**KIRKLEES METROPOLITAN COUNCIL
INVESTMENT & REGENERATION SERVICE**

DELEGATED DECISION TO DETERMINE PLANNING APPLICATIONS

Reference No: 2019/62/90397/E

Description: Erection of front and rear single storey extension and dormers to side

<b>DATE</b>	<b>SCALE</b>	<b>SHEET</b>
13/12/18	1:100	2@A3

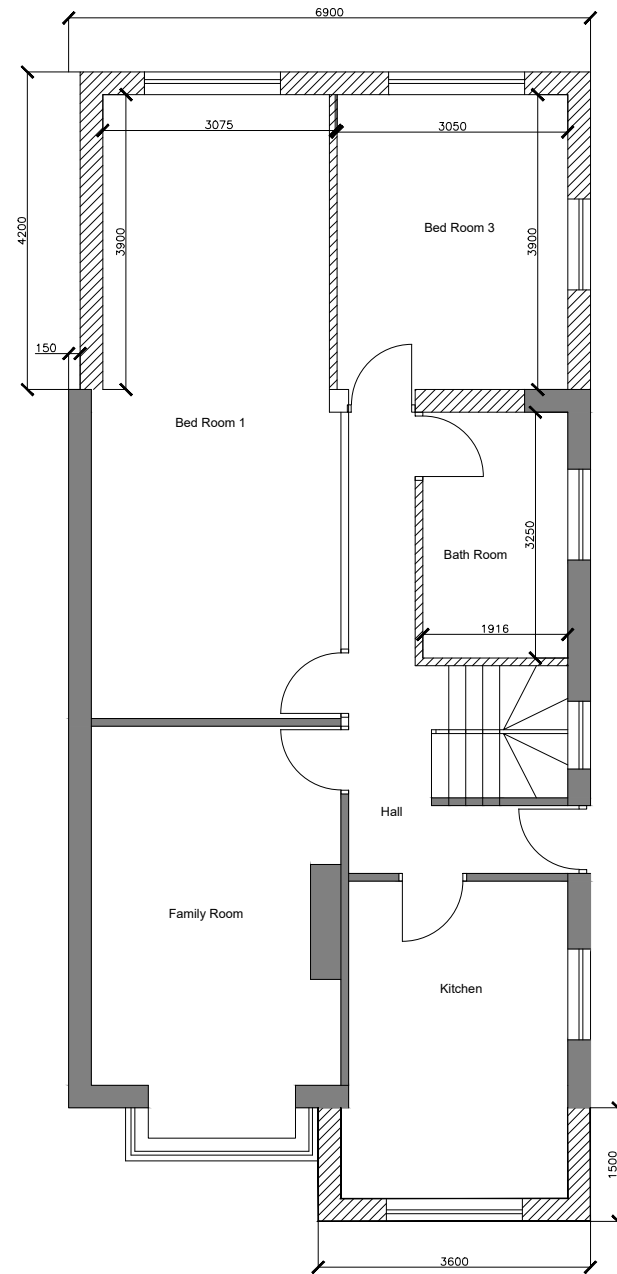
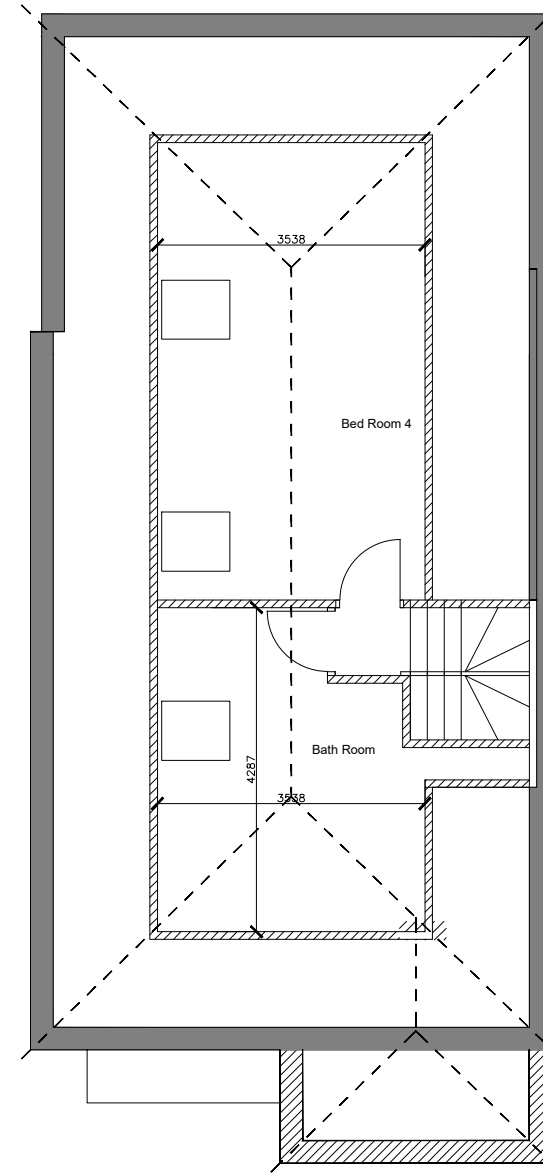
The side wall of the dwelling does form the boundary with the adjacent 4 Squirrel Hall Drive. As the agent had initially signed certificate A, the opportunity was offered to either serve notice and sign certificate B to reflect the overhang which would have occurred or set the side wall of the rear extension in from the boundary. Amended plans were received setting the side wall of the rear extension in 0.15m.

- Also appreciates that the neighbour's garage could mitigate the impact. However, the garage is over 40 years old and nearing the end of its life. If this were to be removed and not replaced the extension may have an unsatisfactory finish with the window proposed in this elevation overlooking the neighbour.

- **Response:** *The application is based on the situation of the site and its surroundings at present. The neighbour's garage is not within the site. Although if this were to be removed, there would be a gap created which would minimise the impact of the rear extension to a degree. The window shown in the side elevation was done so in error and has been removed.*
